REF: AS12069.210310.L1.1

16 March 2021

**AS12069 WROXTON MOTO X TRACK****Noise Impact Assessment Review**

The 'Noise Impact Assessment' submitted with an application to Cherwell District Council for Wroxton Motocross Track, Banbury, has been referred to us at Clarke Saunders Acoustics for technical review.

Figure D.6 – Same event size/different weather conditions - 20-30 bikes – temperature 10 degrees – strong southerly wind

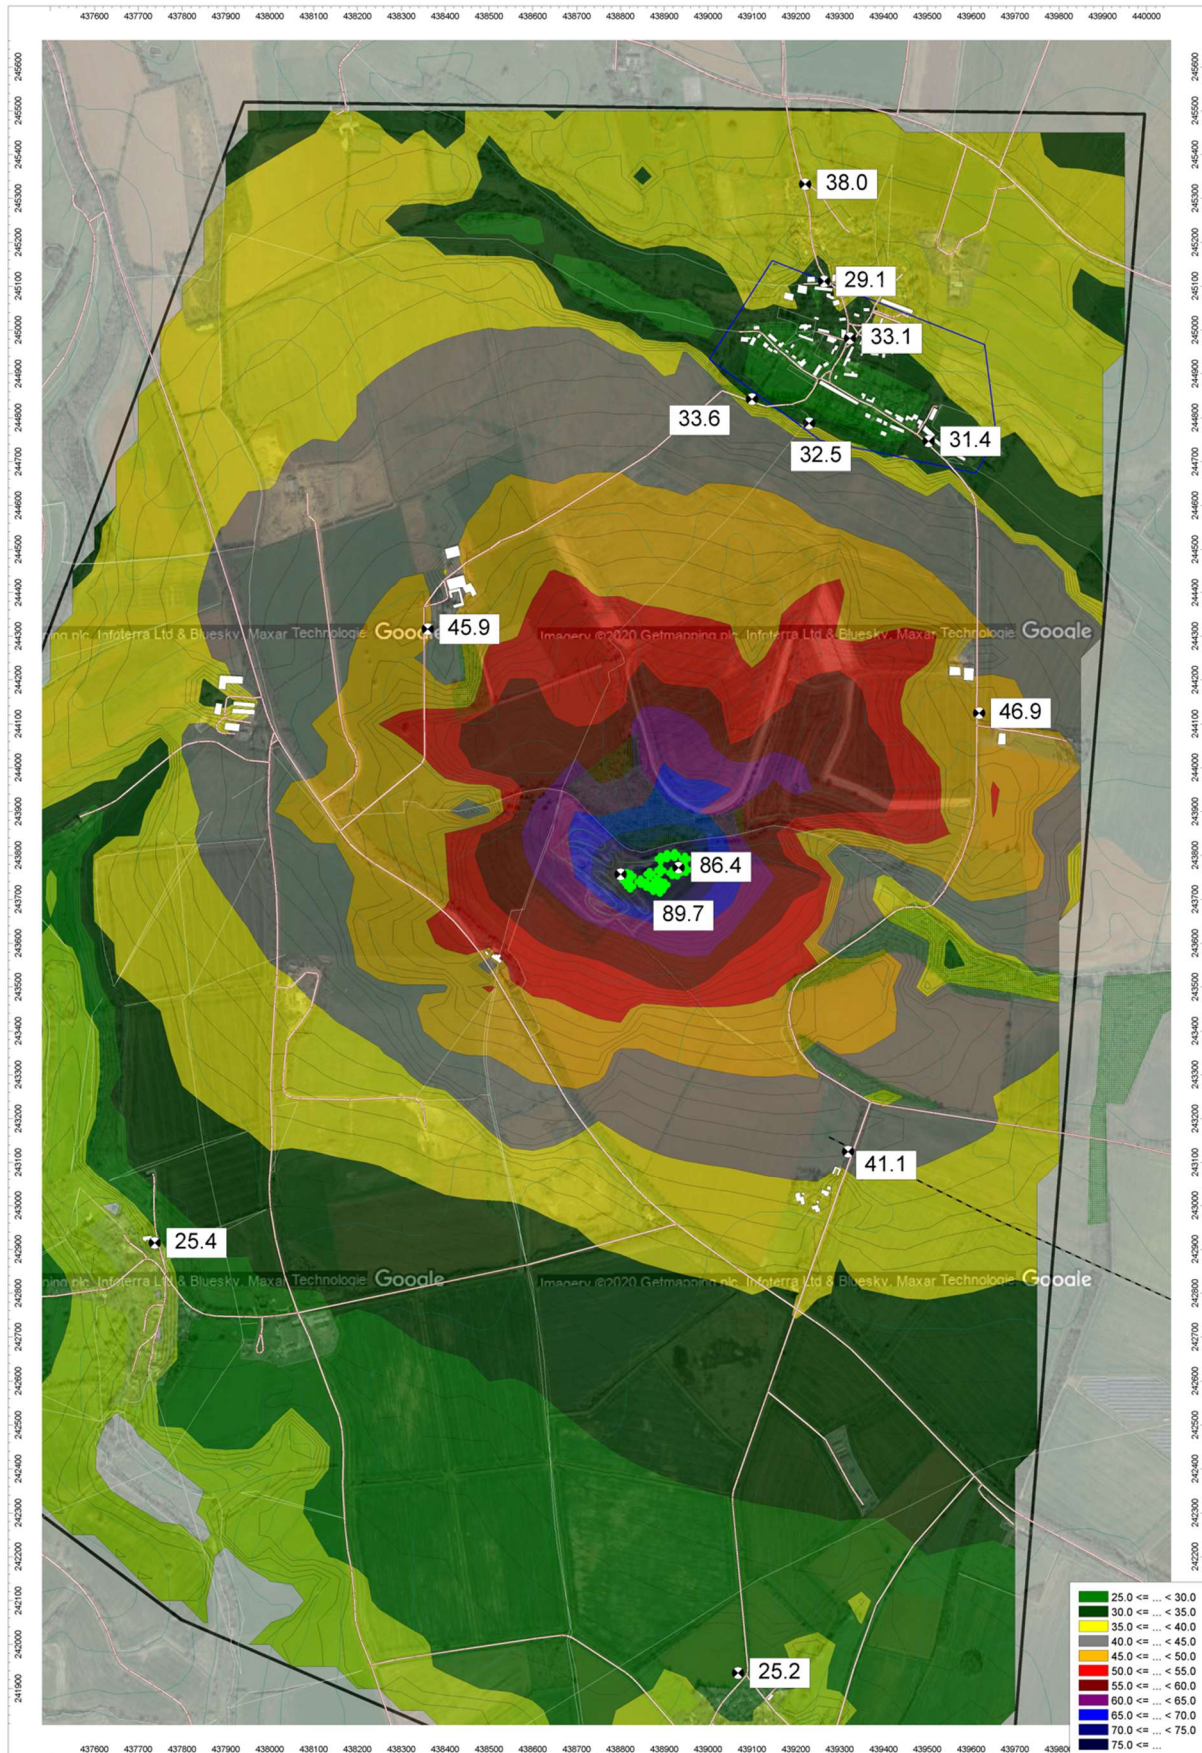
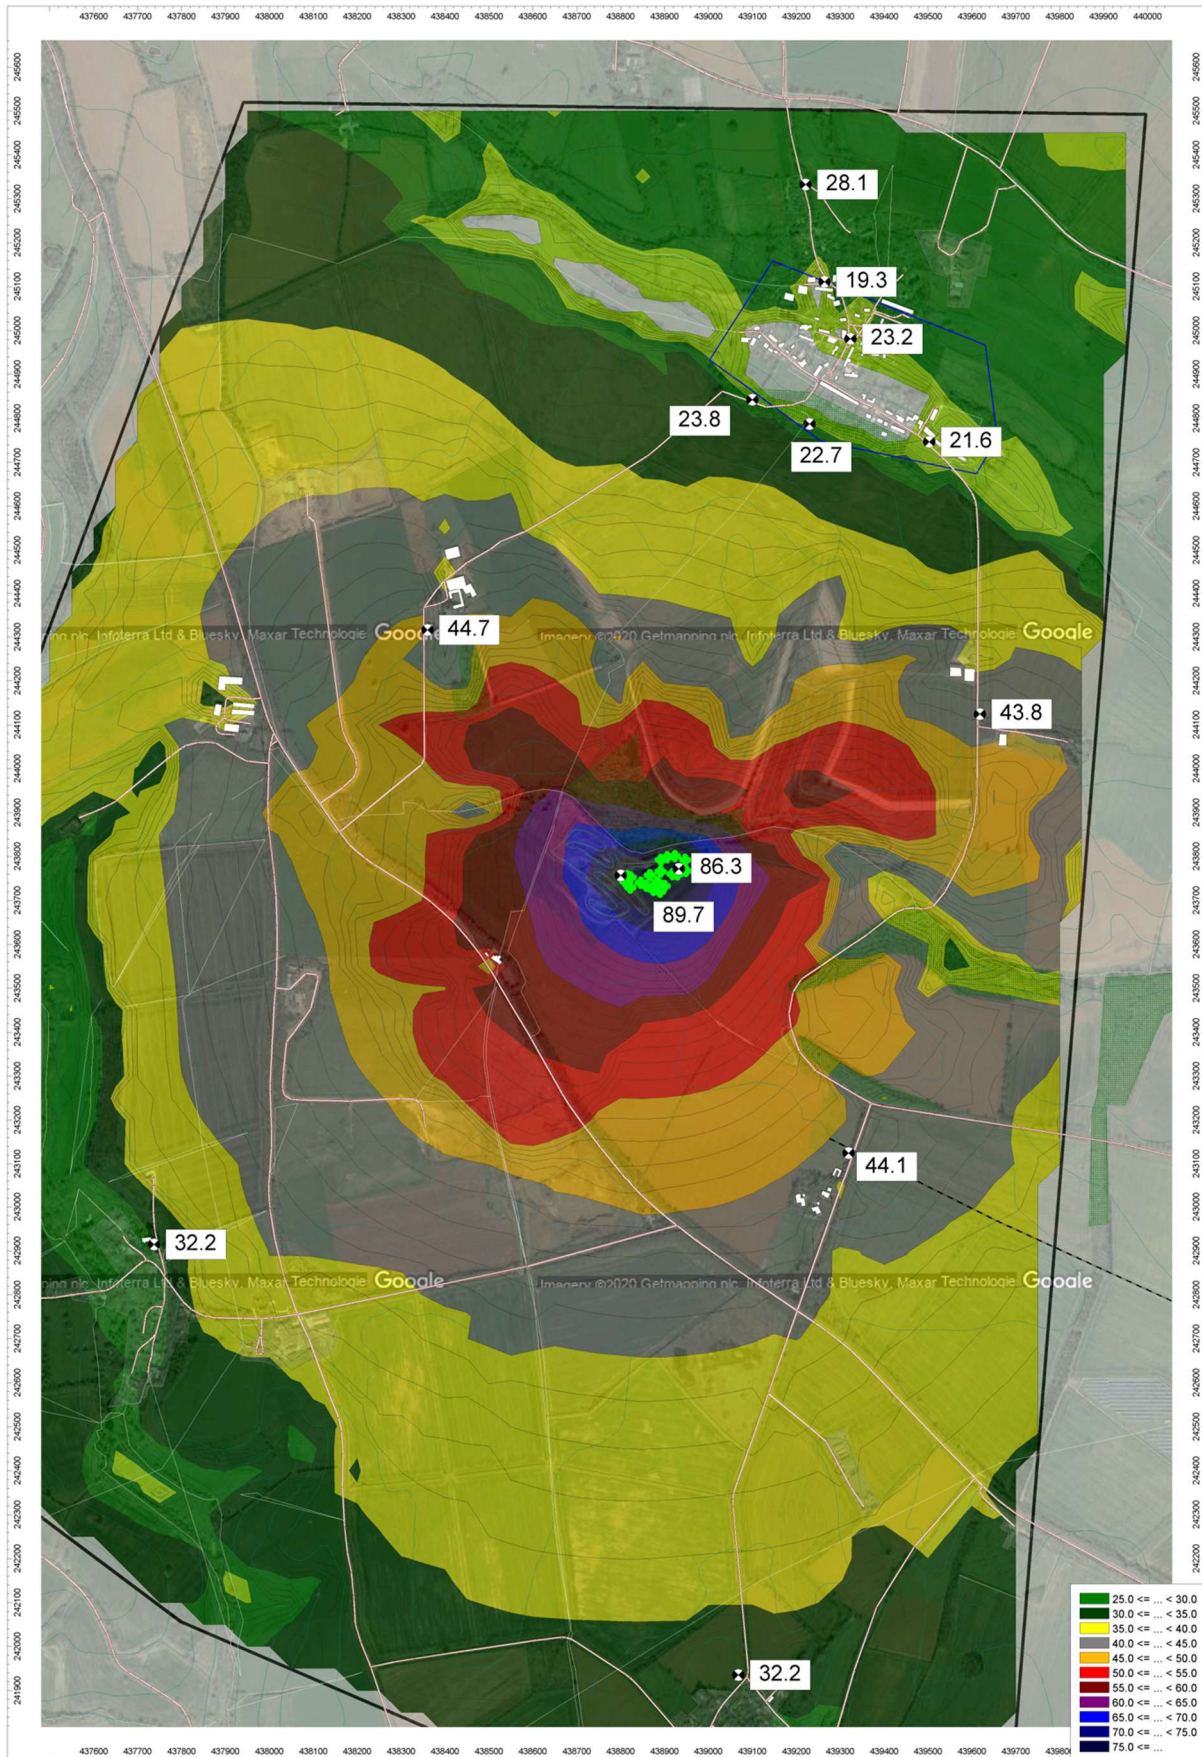
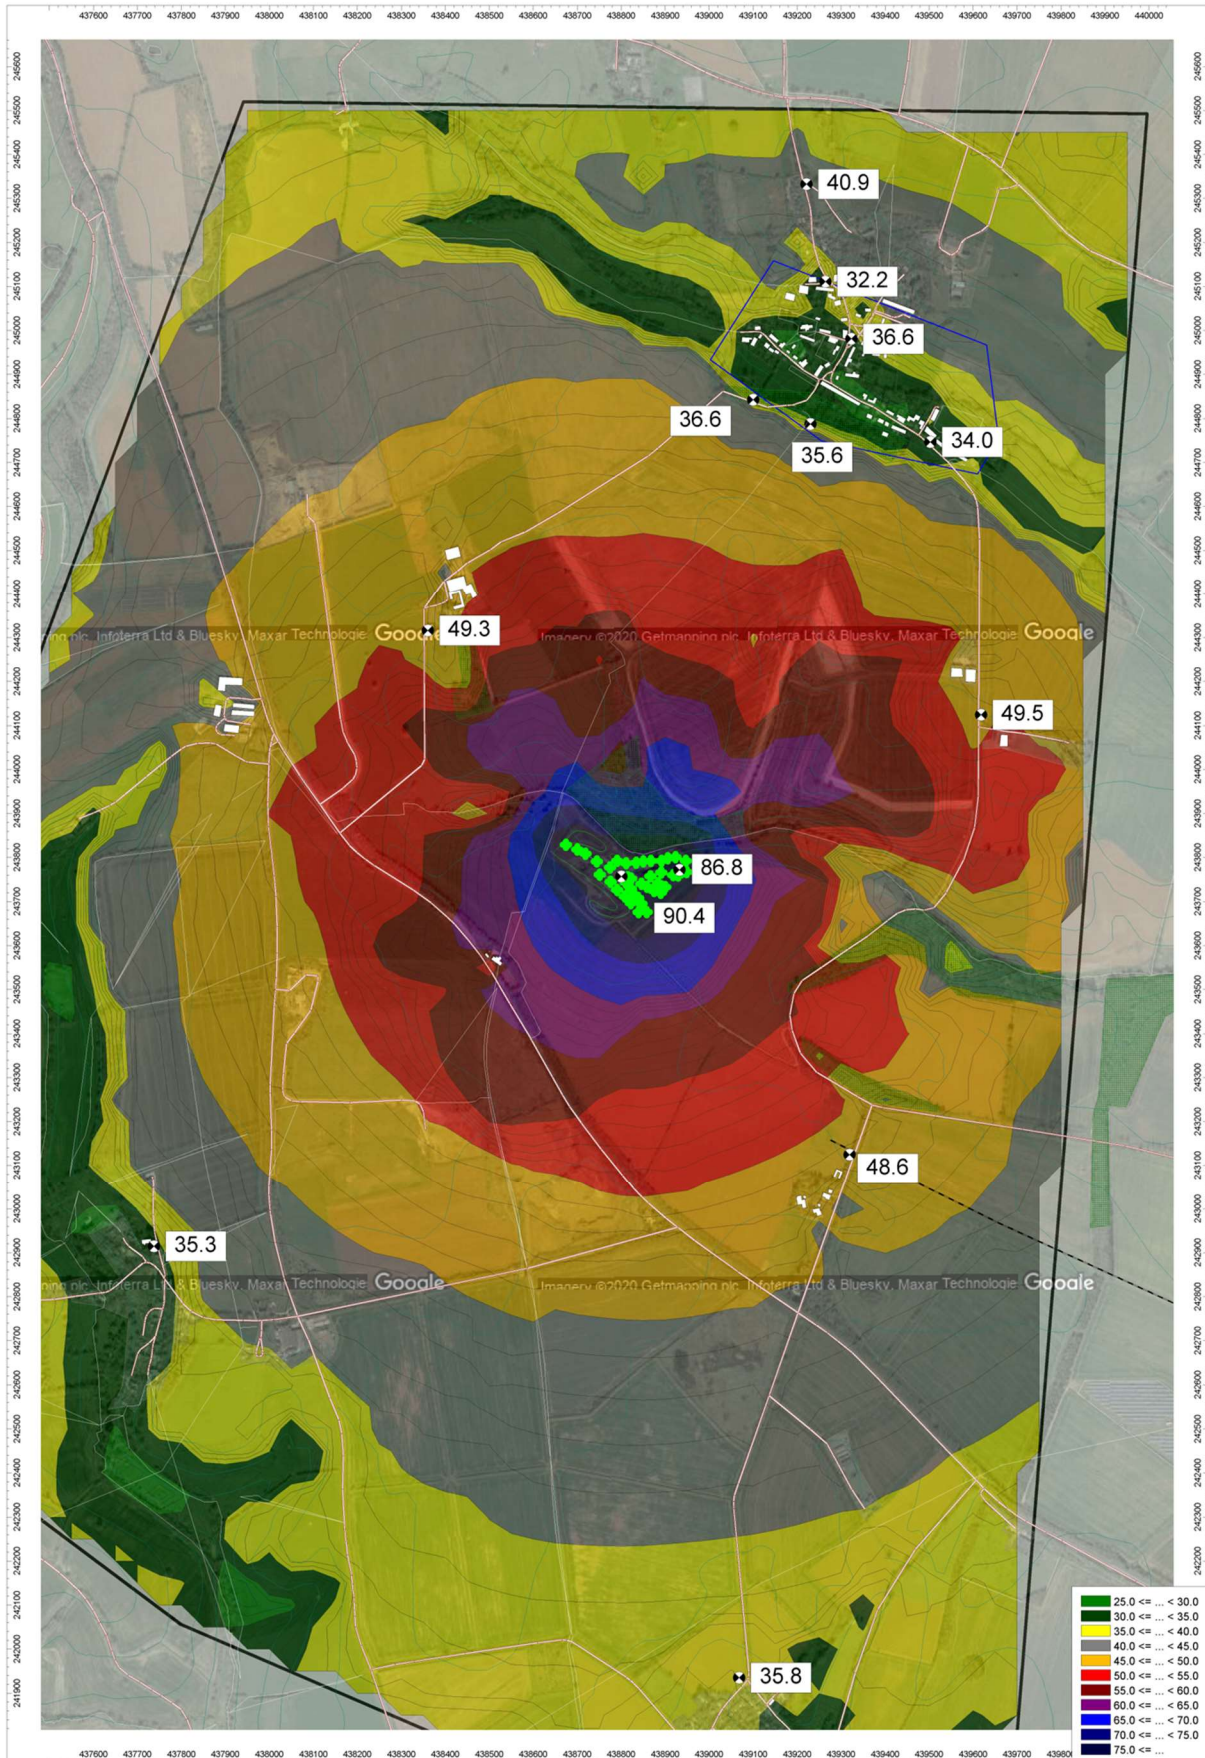
Despite the computer noise modelling presentation of the results, the report submitted describes a very simplistic set of assumptions which can't be relied on to describe motocross noise propagation with any level of precision or reliability without any consideration of these fundamental factors.

The landform of the area places parts of Hornton, for example, in a location which receives a diffracted wavefront which, especially with a southerly wind vector, focusses low frequency exhaust noise to produce higher levels than some locations closer to the track. When combined with receptor locations at which otherwise prevailing background levels are particularly low, the resultant impact will be particularly noticeable. The submitted report contains none of this level of detail or nuance.

No consideration has been given to source directivity in the noise modelling prediction either. With the strong directivity of exhaust noise the orientation of the machines and hence the track circulation orientation become significant factors. This becomes even more significant when taking into account the undulating track features, resulting in increased power output from the engines which at times are significantly higher than the local ground level when airborne over jumps.

Finally, but perhaps most significantly the influence of weather conditions on long range sound transmission is the most important variable of all, having much more influence than variation in number or types of vehicle, for example. The effect must be a factor in the discussion of impacts, numbers of days' exposure, which of the receptors are the most critical with respect to prevailing wind conditions and so on. The author states "*these levels wouldn't be particularly affected by different weather conditions, strong winds would not cause an increase in levels at receptors in the direction of the wind, but would actually benefit those in the opposite direction.*"

There is no reference to prevailing or typical conditions, or the conditions under which the worst-case impact occurs (and the statistical rate of recurrence of those conditions). Distance propagation calculations are prone to significant error if they are not tested and corrected under different meteorological conditions. Any attempts at 'crude predictions' provide no meaningful insight. The biggest variable in motorsport noise assessment is the weather, which dramatically affects the propagation of both activity noise and the ambient noise against which it is assessed, and insufficient consideration has been given to this factor.

Historical weather data shows records a northerly wind on the day of the noise survey, with the implication that noise propagation towards Hornton would have been lower than with a more typical prevailing wind, which would have a southerly component. When the wind speed gradient is aligned with the direction of sound propagation it effectively imparts 'top spin' to the propagating wavefront which would effectively undermine the screening influence of the intervening hill between the circuit and the village of Hornton.
